February 16, 2023

Subject: SUB22-006 (Premium Homes of Mercer Island Preliminary Short Subdivision)
Request for Information #1

In response to the City of Mercer Island comment letter dated December 22, 2022, we have completed the revisions to SUB22-006 (Premium Homes of Mercer Island Preliminary Short Subdivision). The following is a description of the revisions.

TREE REMOVAL, RETENTION & PLANTING PLAN

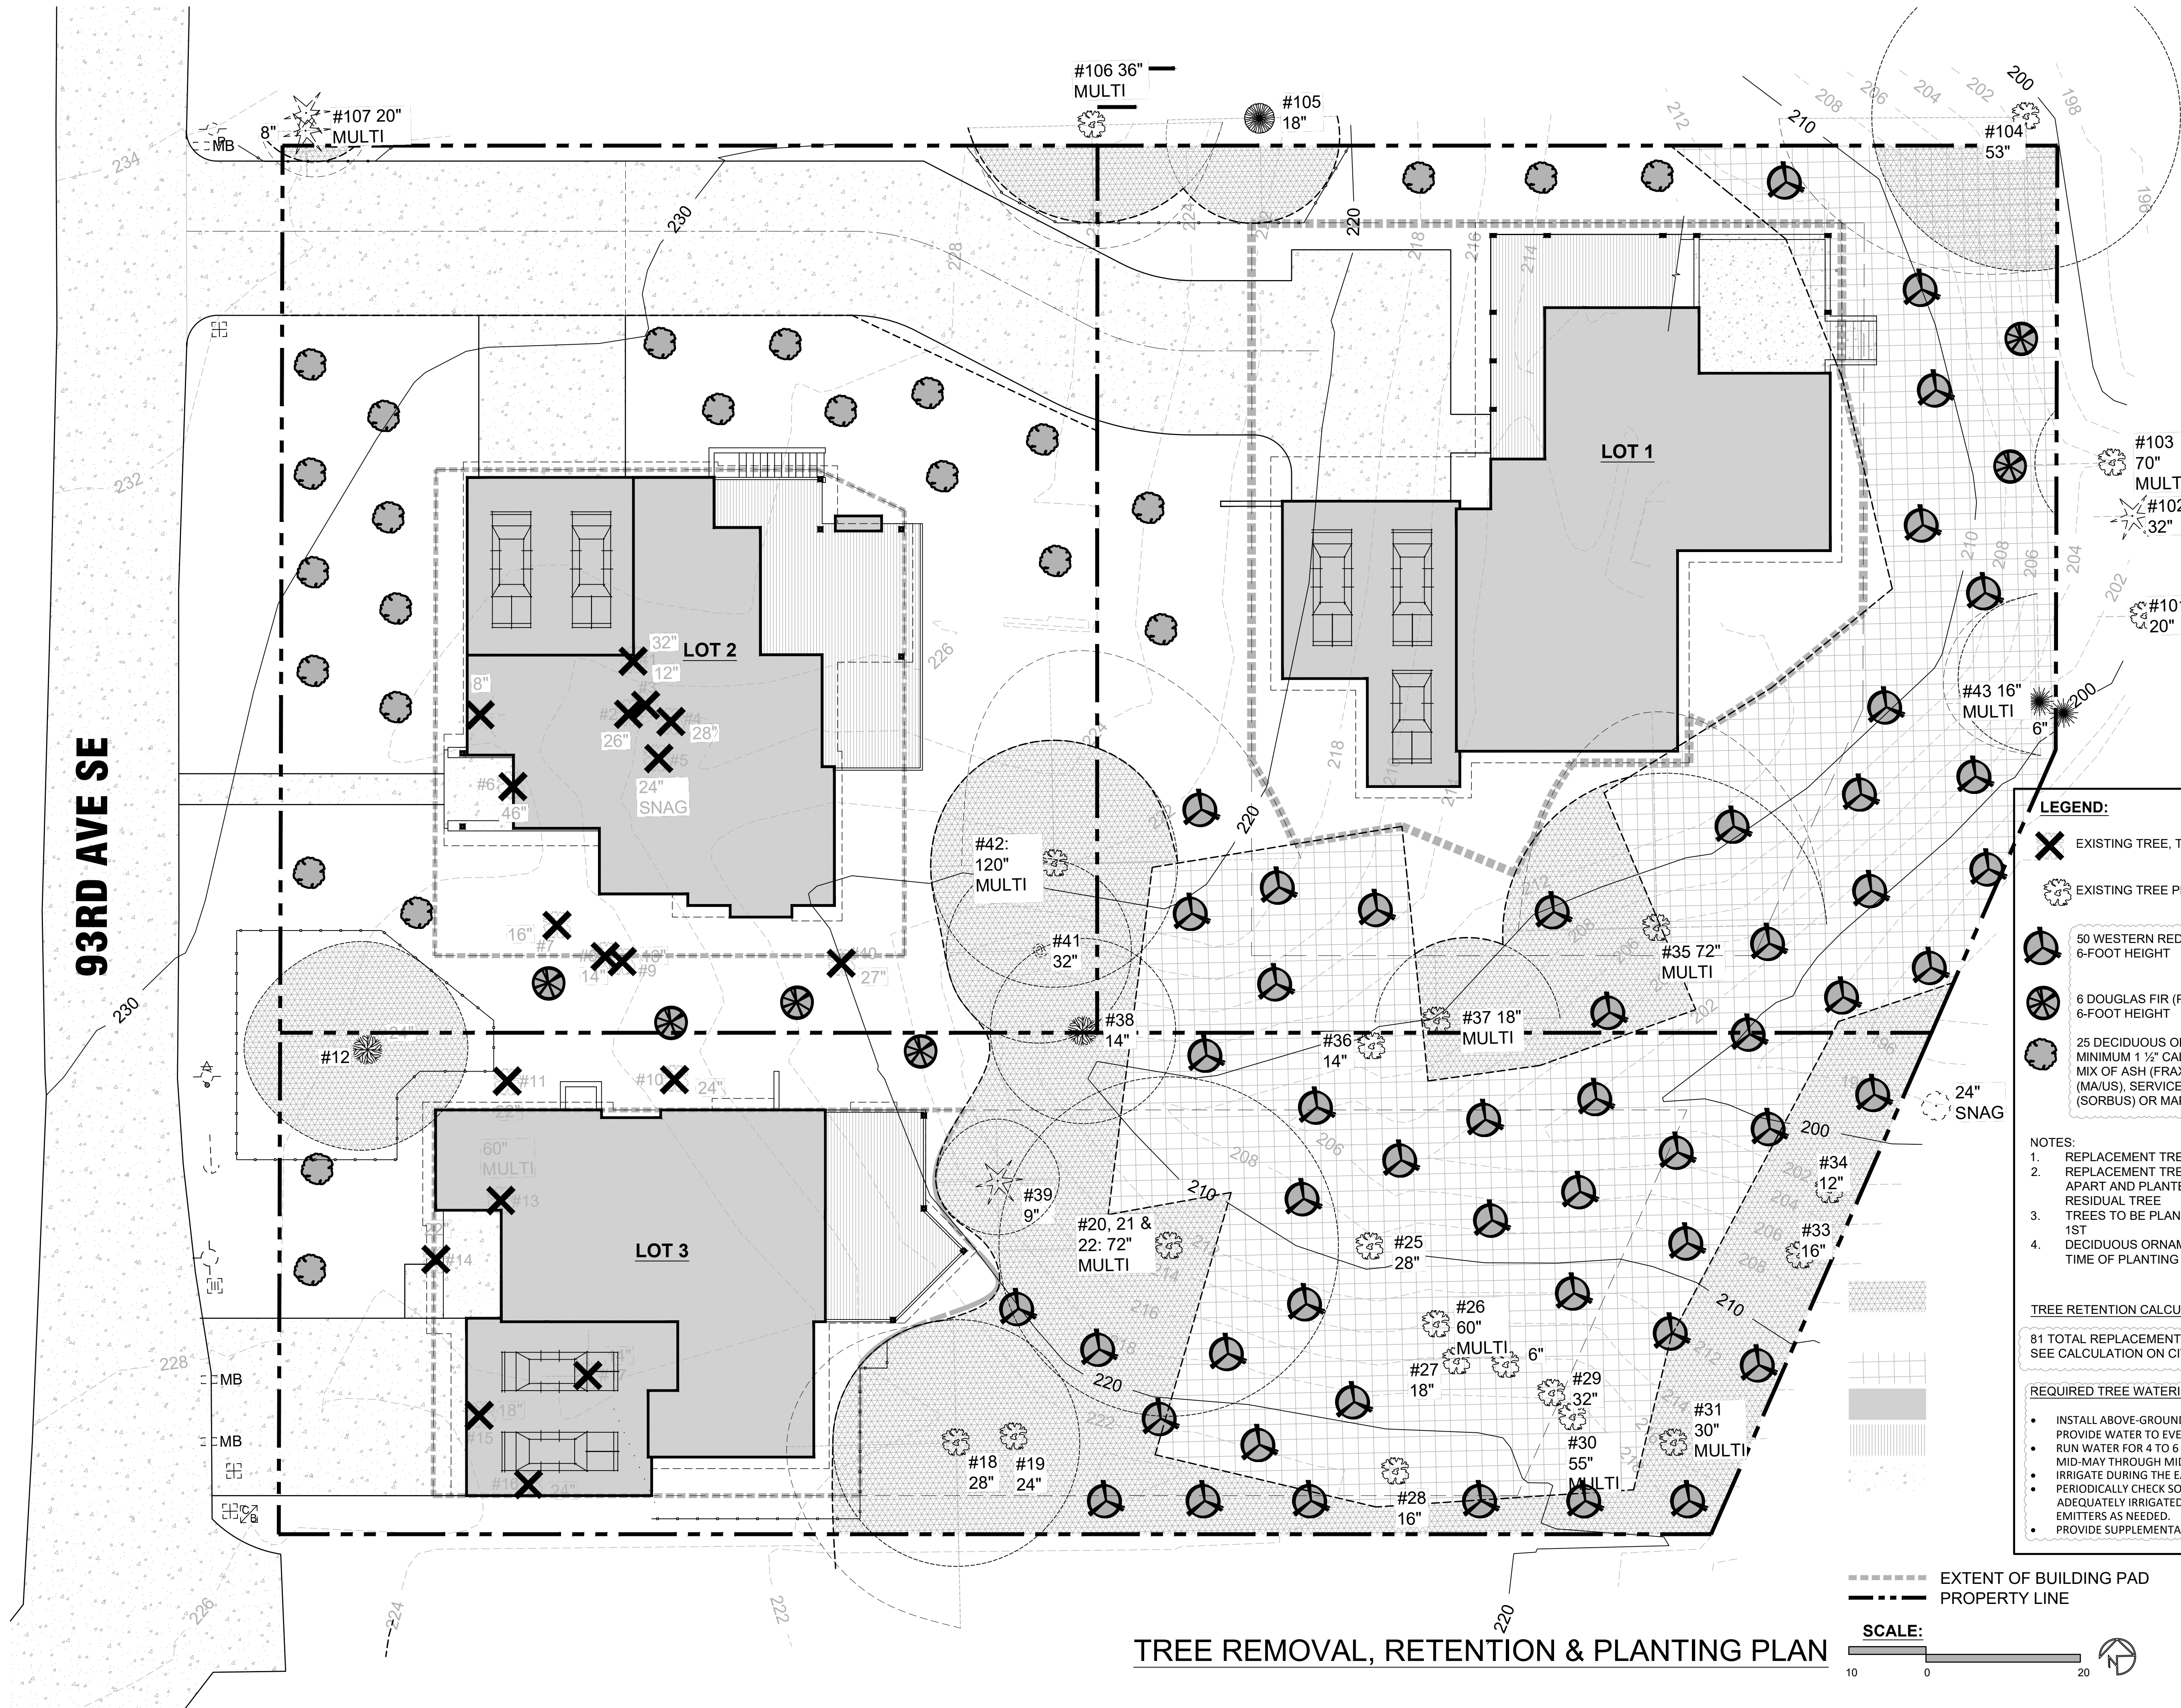
2. (For landscape architect) The application material shows that 74 replacement trees are proposed. 81 trees are required to be planted, assuming that Tree 12 will be retained. If the removal of Tree 12 can be justified under MICC 19.10.060, an additional 6 trees will need to be replanted. At least half of the trees will need to be native to the Pacific Northwest. The trees will need to be at least 10 feet apart from each other, structures, fences, and utilities. If requested, and if you can demonstrate that no room exists on site for all the trees, you can request that the remainder be a fee in lieu. A tree watering plan must be submitted to ensure the trees survive long term.

Refer to response letter prepared by McCollough Architects.

**PRELIMINARY CIVIL SITE PLAN**  
**SHORT PLAT - 93RD AVE SE**  
**SUB22-006**  
PREMIUM HOMES OF MERCER ISLAND LLC  
MERCER ISLAND, WA 98040  
(206) 724-1072

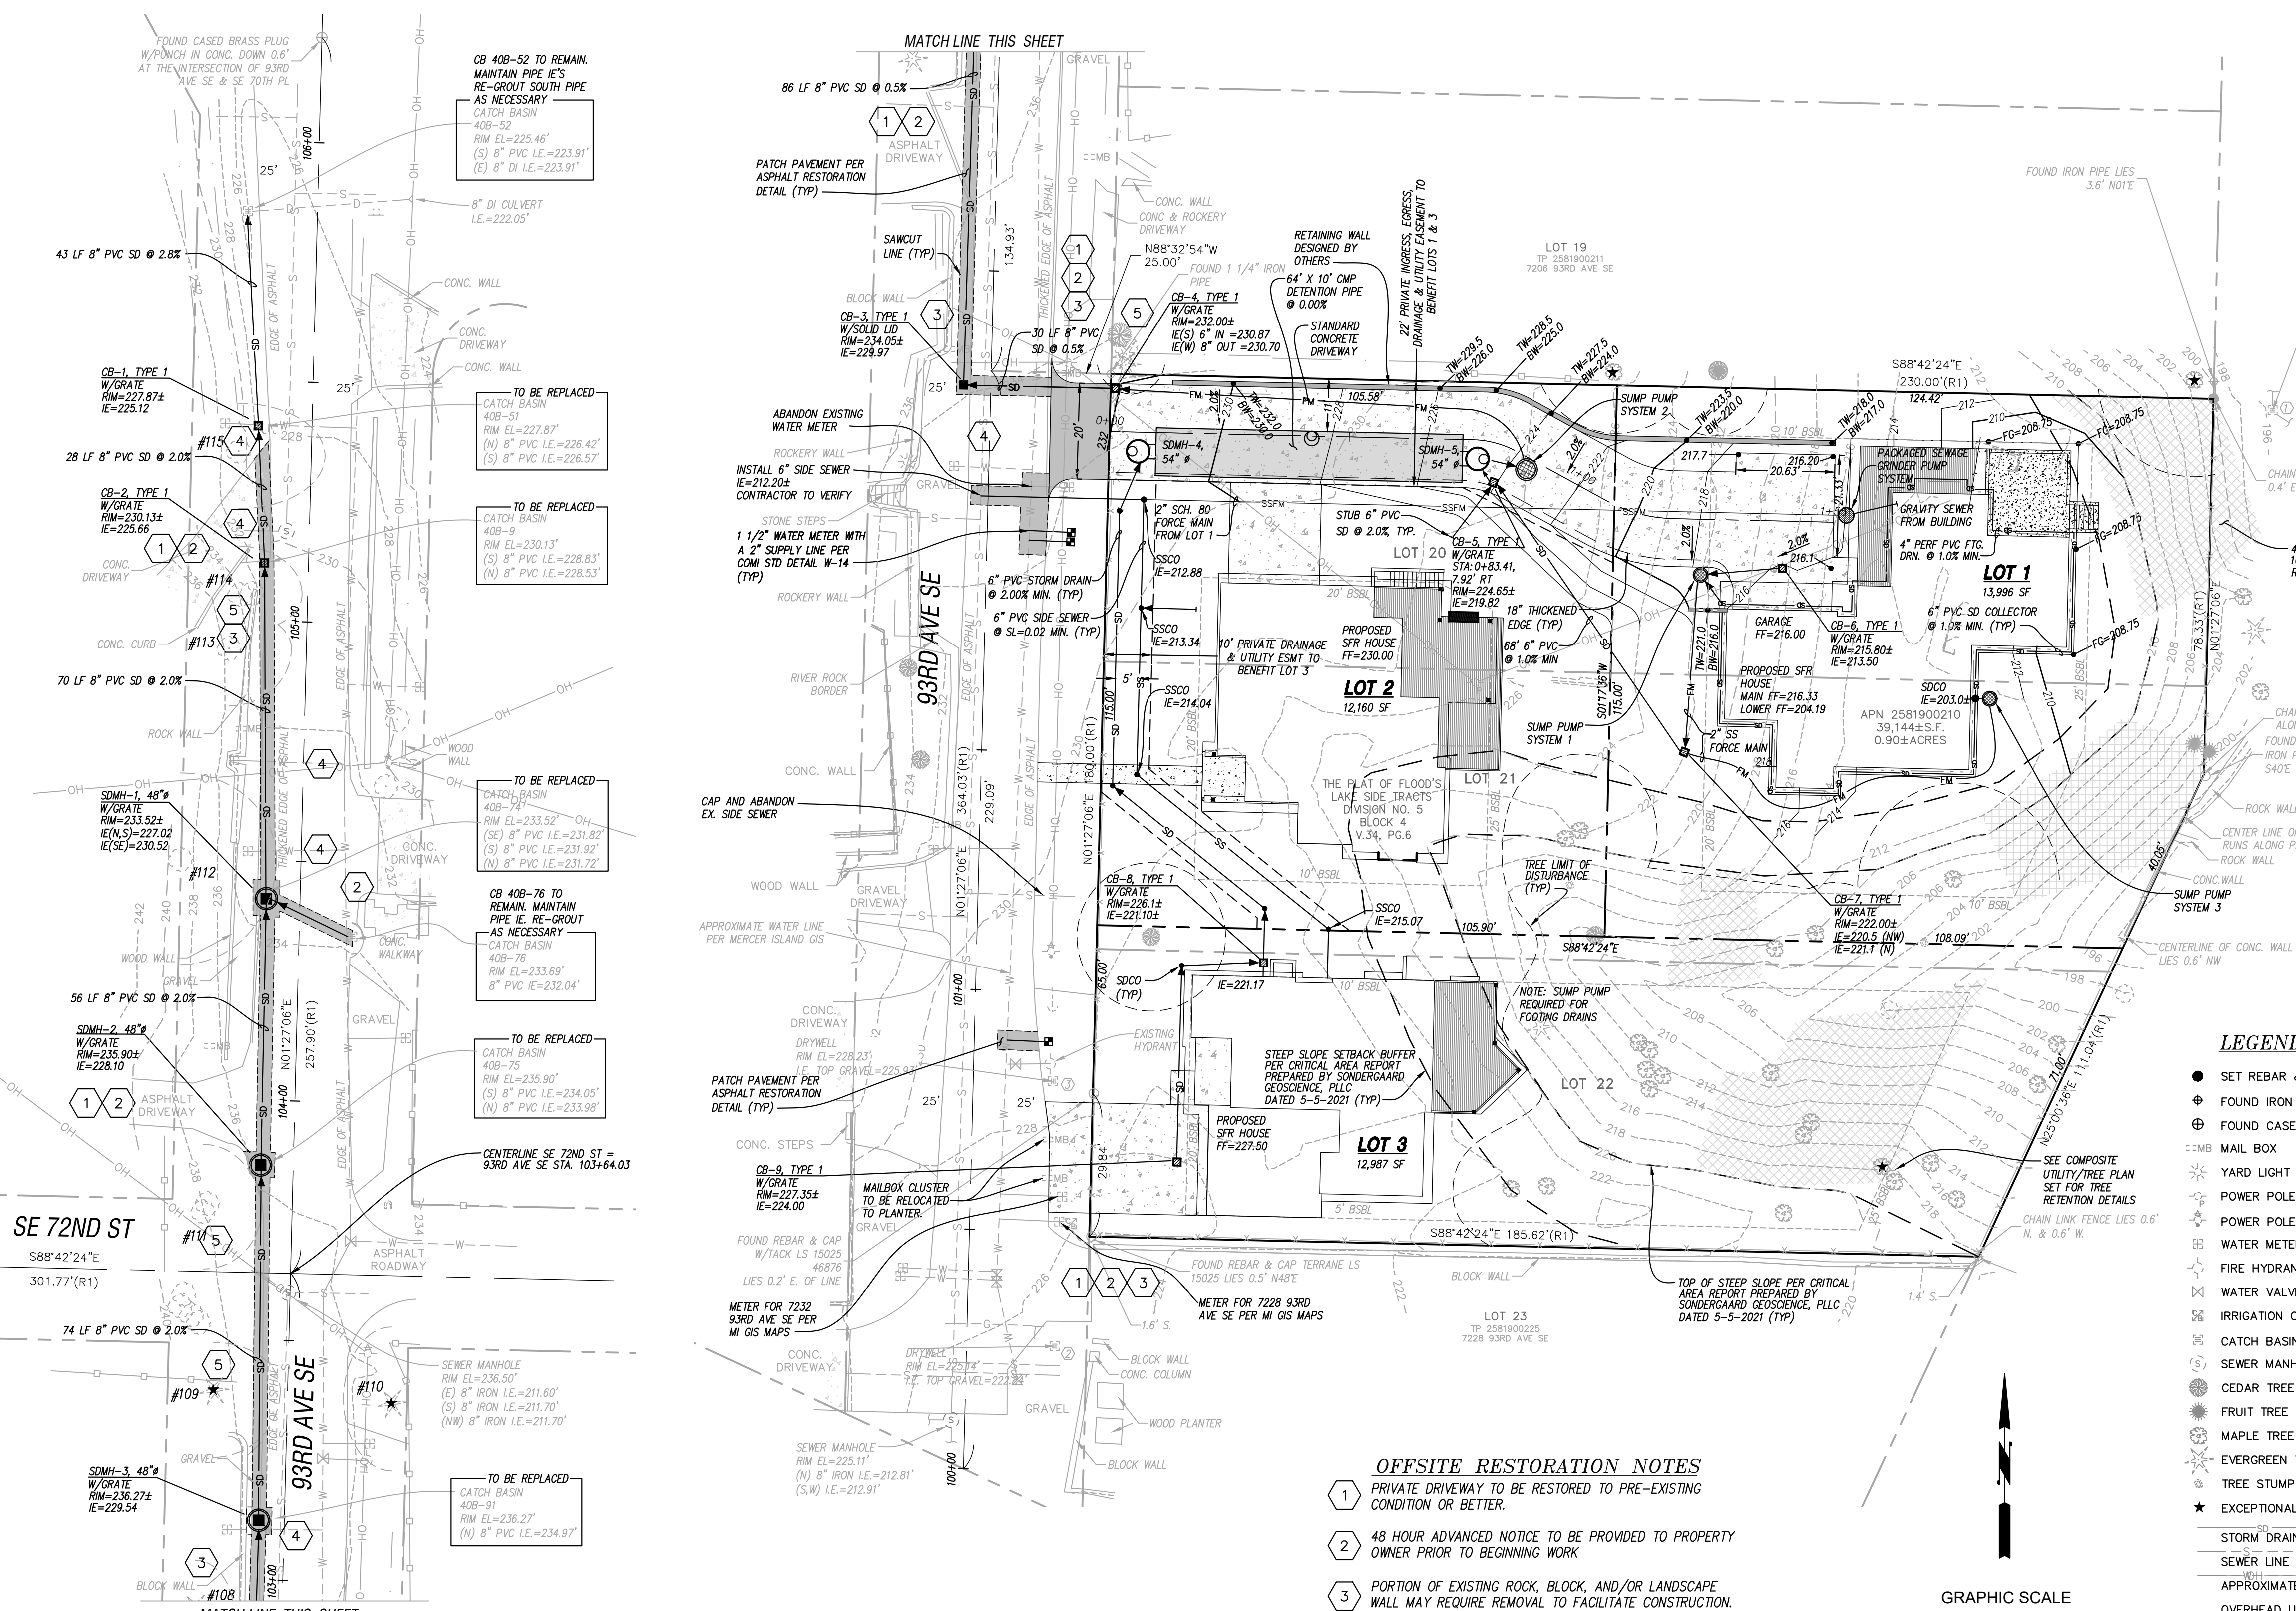
1. Please clearly indicate if the ingress, egress, drainage, and utility easement on the north side of Lot 2, as shown on Sheet 2 of 2 on the plans, is a public or private easement.
The easement callout has been revised to clarify that the easement is private.
2. Please clearly indicate which lots are benefited by the 10-foot private sewer on the west side of Lot 2, as shown on Sheet 2 of 2 on the plans.
The easement callout has been revised to indicate that the easement is for the benefit of Lot 3.
